Elevation Plans_V1.pdf Markup Summary

6/27/2022 9:39:02 PM (1)

By: \_\_\_\_\_  
Name: \_\_\_\_\_

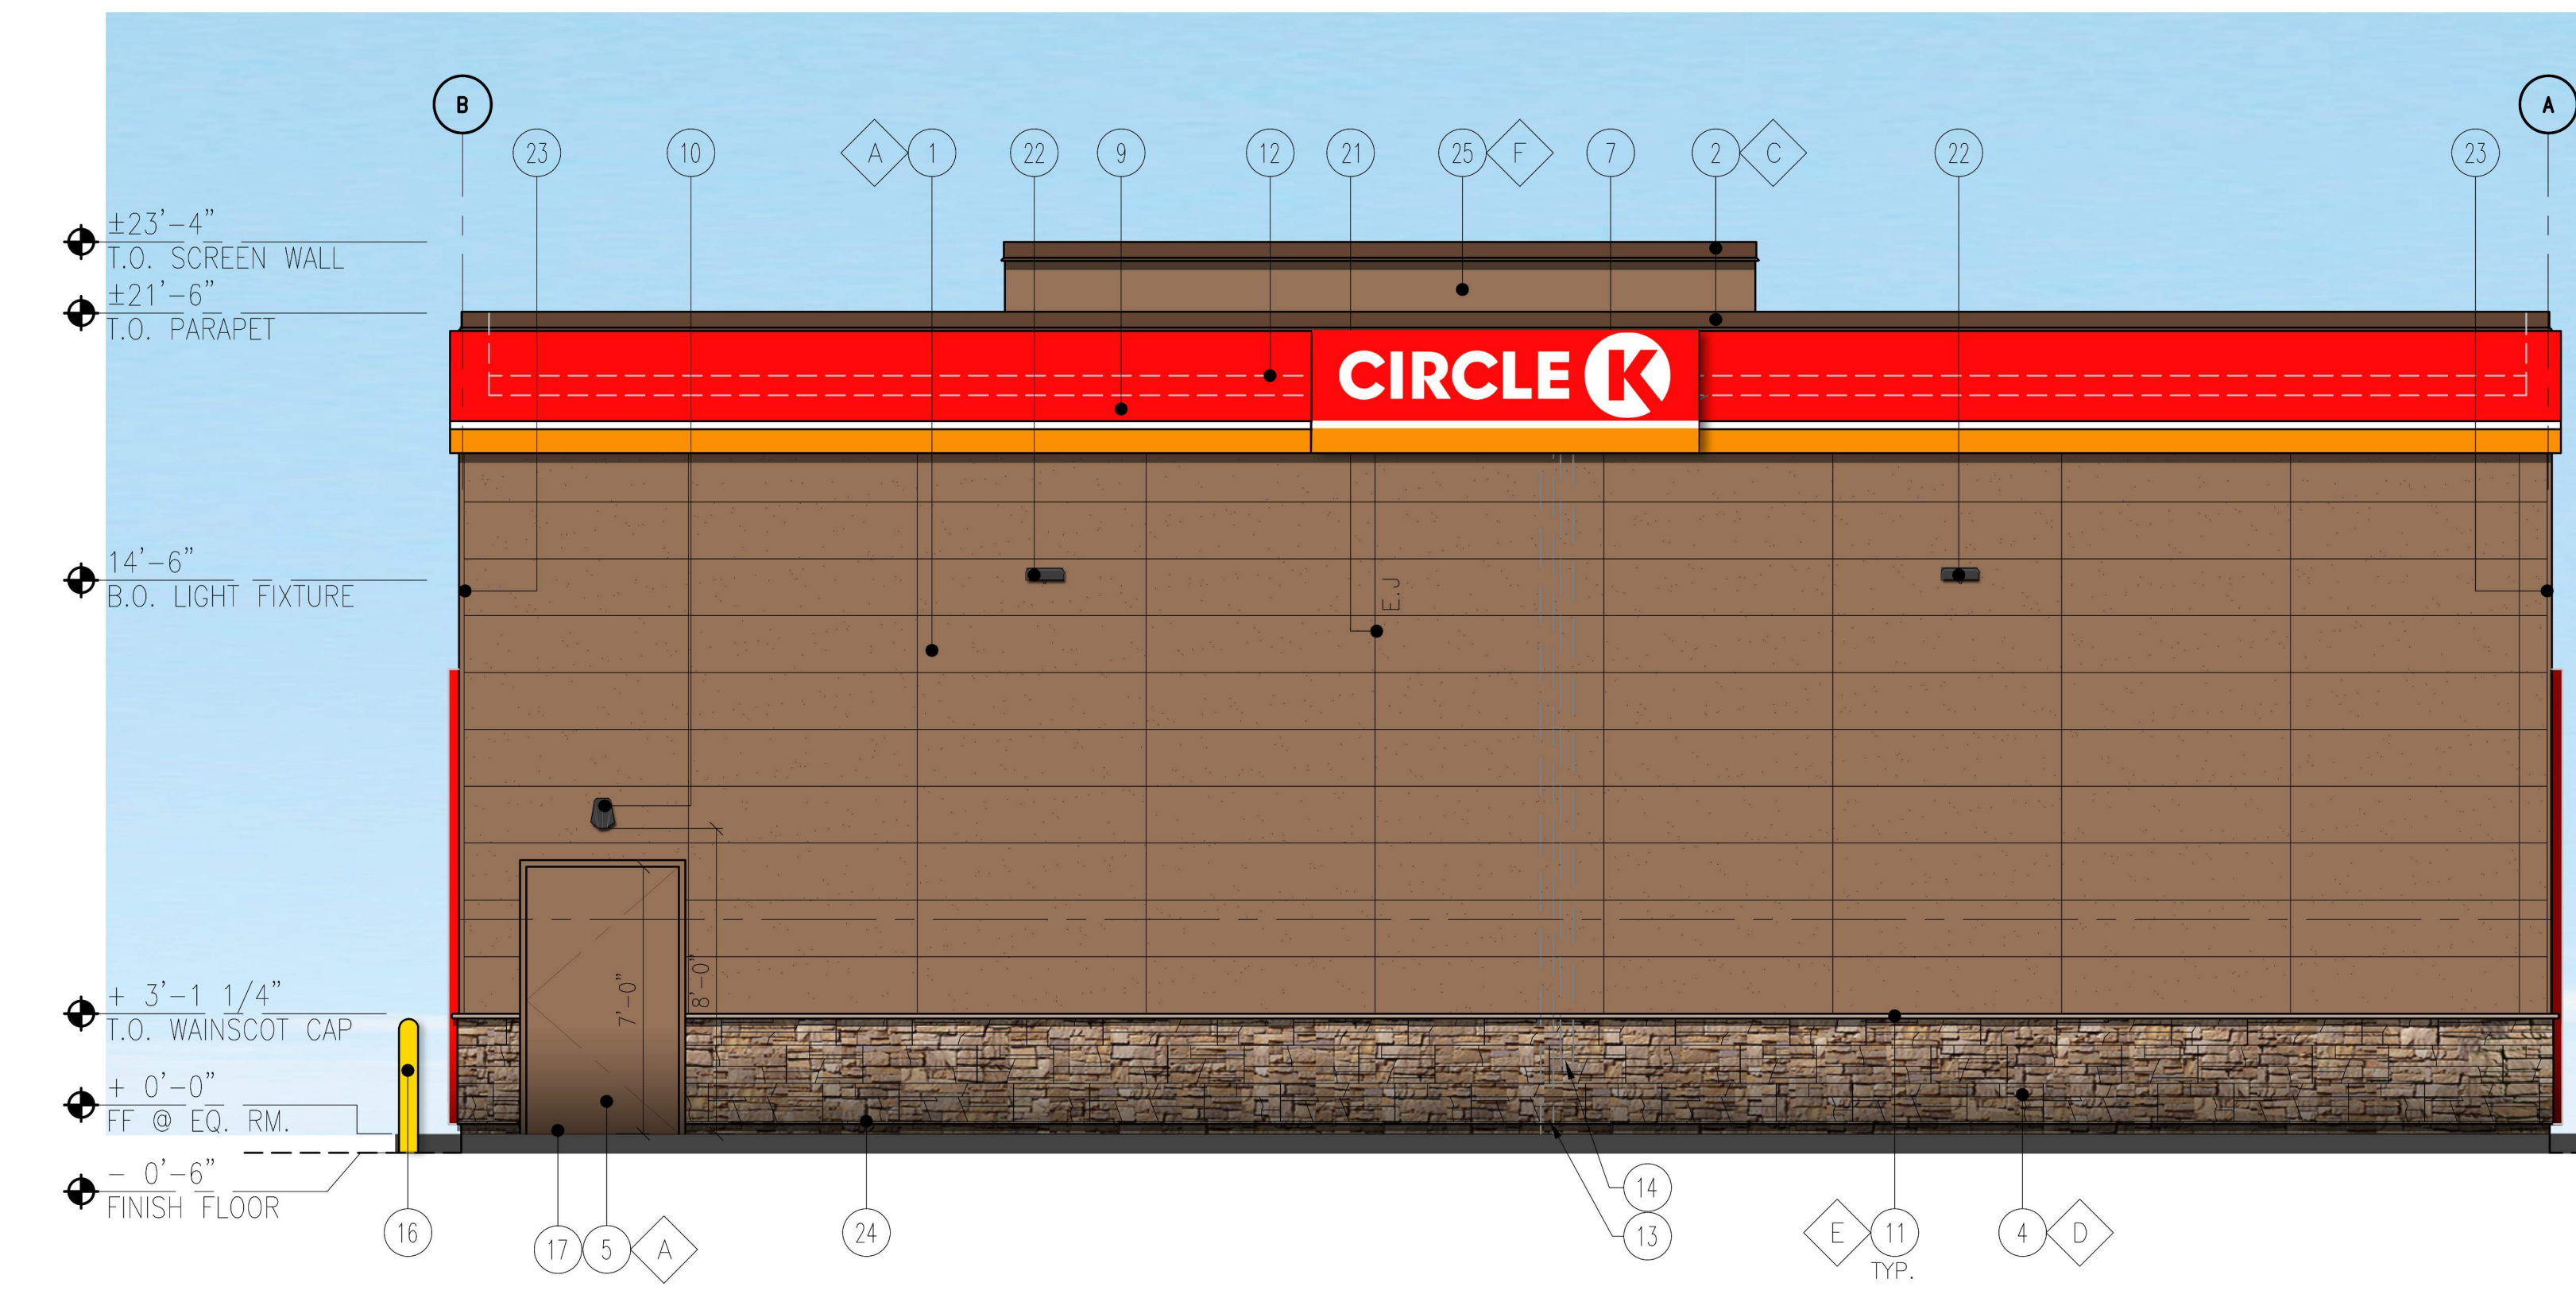
Include Signature block for the Planning and Community Development Director a minimum of 1 inch by 2 inch.

Include Signature block for the Planning and Community Development Director a minimum of 1 inch by 2 inch.

Include Signature block for the Planning and Community Development Director a minimum of 1 inch by 2 inch.
